City of Portland, Maine - Building or Use Permit Application

Permit No: 05-1515	Issue Date: NOV 13 2003	Est. No: 310 F017001
Location of Construction: 24 FARNHAM ST	Owner Name: WENDT SCOTT A & TINA L WE	Owner Address: 24 FARNHAM ST
Business Name: Maines Best Home Improvement Co	Contractor Name: Maines Best Home Improvement Co	Contractor Address: P O Box 23 10 Scarborough
Lessee/Buyer's Name	Phone:	Permit Type: Alterations - Dwellings

Past Use: Single Family	Proposed Use: Single Family demo existing garage and replace w/ 2 car garage	Permit Fee: \$237.00	Cost of Work: \$23,549.00	CEO District: 5
Proposed Project Description: Demo existing garage and replace w/ 2 car garage		FIRE DEPT: <input type="checkbox"/> Approved <input type="checkbox"/> Denied	INSPECTION: Use Group: <i>RM</i> Type: <i>SB</i>	
Signature: _____		Signature: <i>IRC-2003</i> <i>AMB 11/15/05</i>		
Action: <input type="checkbox"/> Approved <input type="checkbox"/> Approved w/Conditions <input type="checkbox"/> Denied		Date: _____

PLOT PLAN

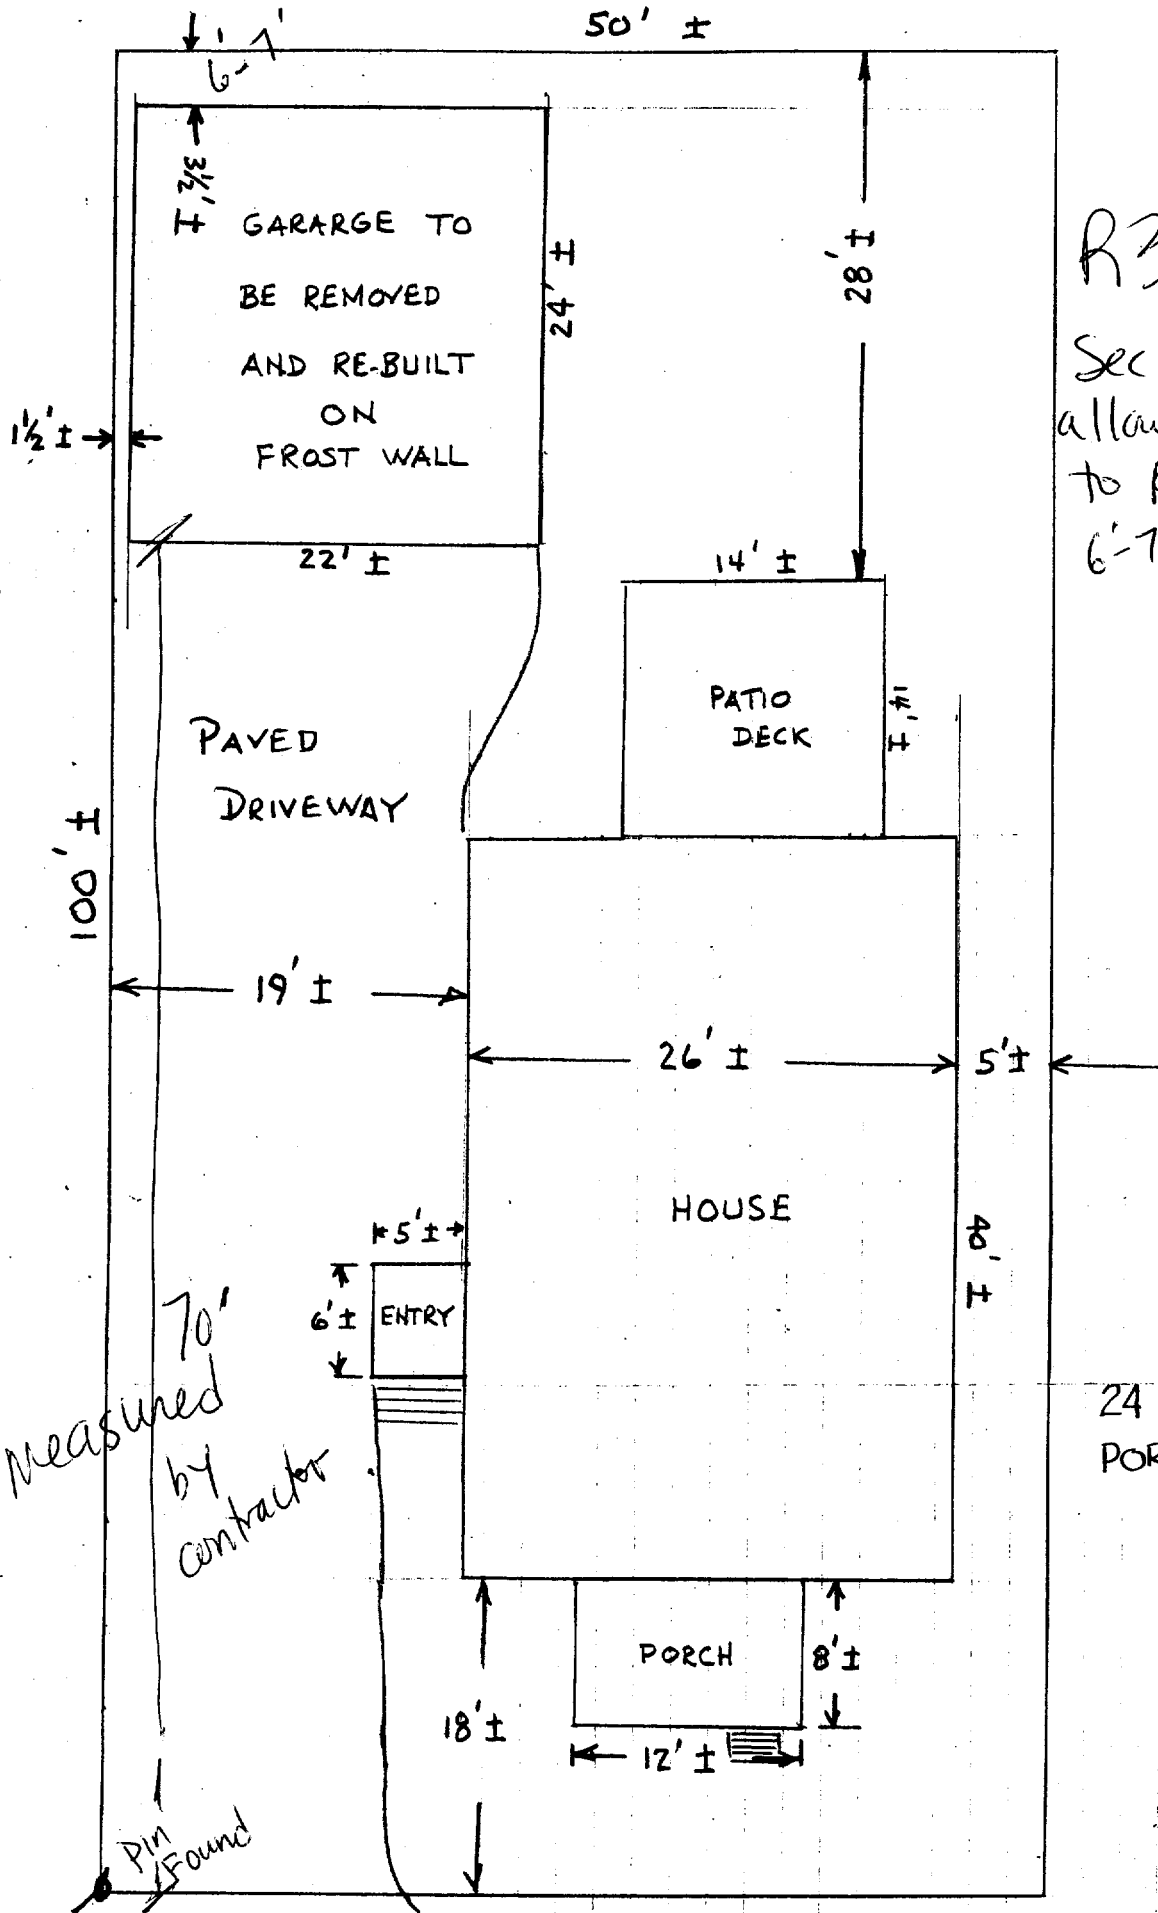
1) Approved using Sec. 14-433 to decrease the rear setback to a min. Of 5' due to the slight increase in the footprint of the nonconforming garage

11/03/2005-jimb: Pre-demo shows the existing garage is smaller than the proposed garage, and the shed extension is shorter than the garage roof, left vm w/owner & contractor.

11/09/2005-jimb: Left vm w/Reggie B. About research & asked if there was a mortgage survey showing the garage extension. He will check w/owners. Also explained exception possibility.
 He called back to say he found the left front property marker and measured 70' exactly to the front of the existing garage. With a 24' garage, this would give a 6' rear setback based on 100'. He agreed to move the garage forward 1' just to make sure. He will get back on 11/14 w/info.
